Historic England

**Application by Rampion Extension Development Limited for an Order Granting Development Consent for the Rampion 2 Offshore Wind Farm
PINs Ref: EN010117**

DEADLINE 4 SUBMISSION – COMMENTS ON DOCUMENT SUBMITTED BY THE APPLICANT AT DEADLINE 3 (25th APRIL 2024) AND MATTERS ADDRESSED AT ISSUE SPECIFIC HEARING ON 16th MAY 2024

Graphic 6-1 Flowchart summarising the embedded environmental measures and how they are applied pro-actively throughout the life of the project (Table 6-1)

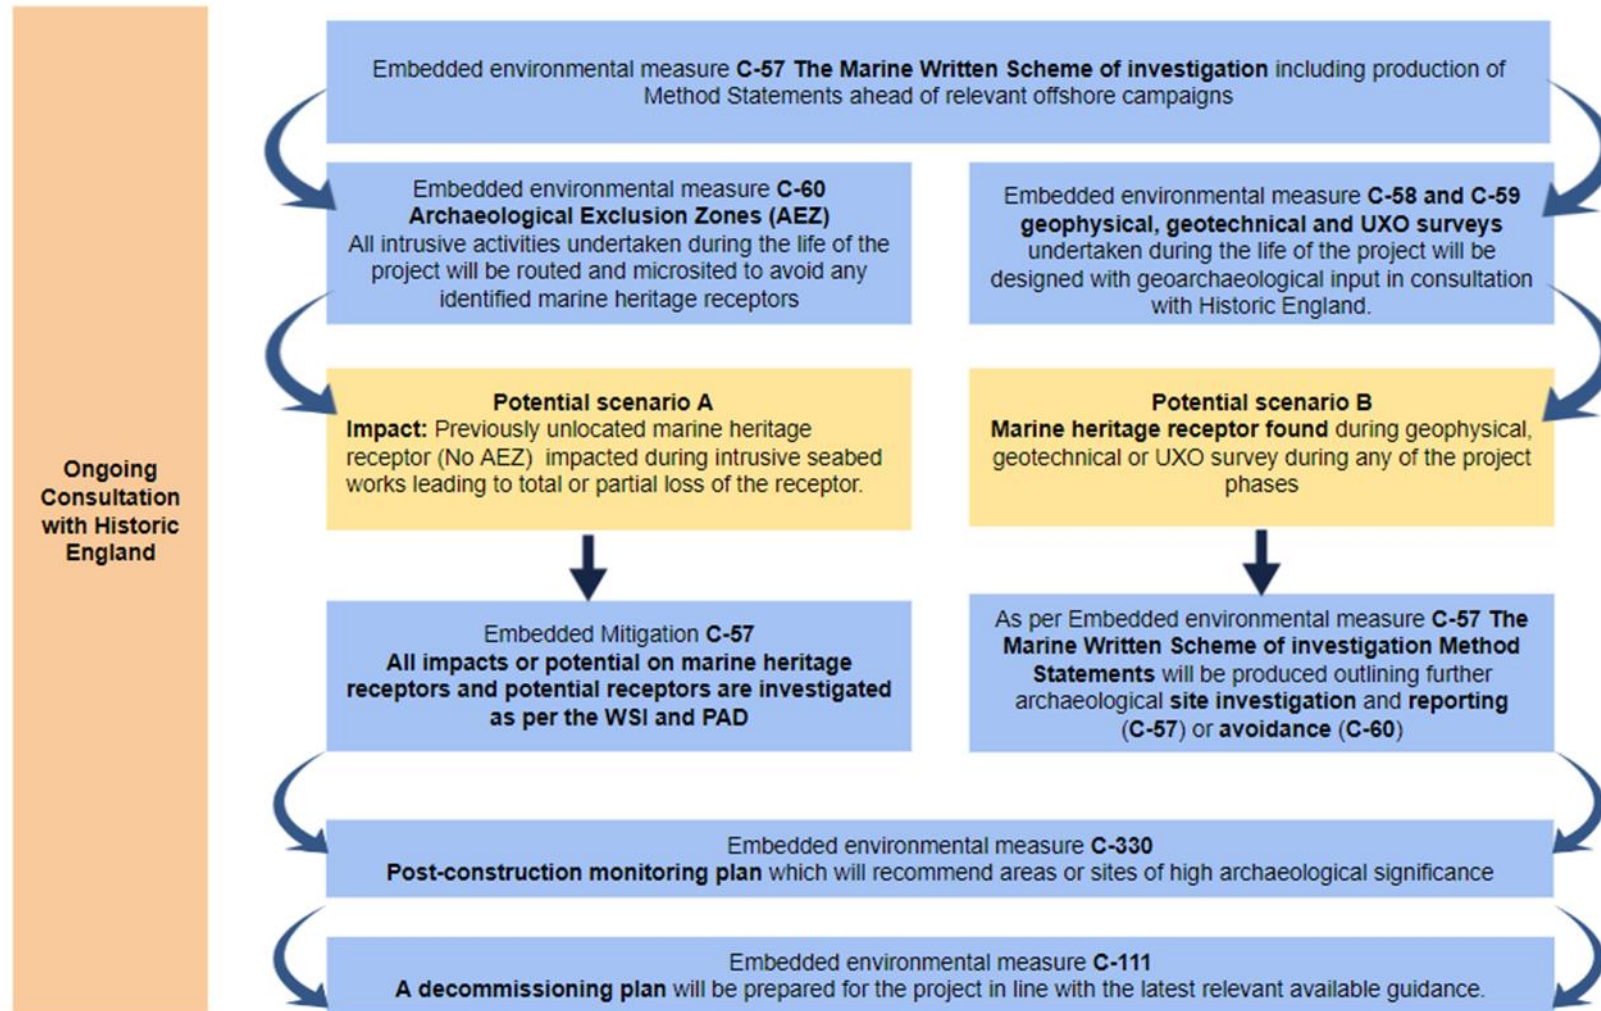
2.4 Section 6 (Embedded environmental measures) we accept the edits introduced on Table 6-1.
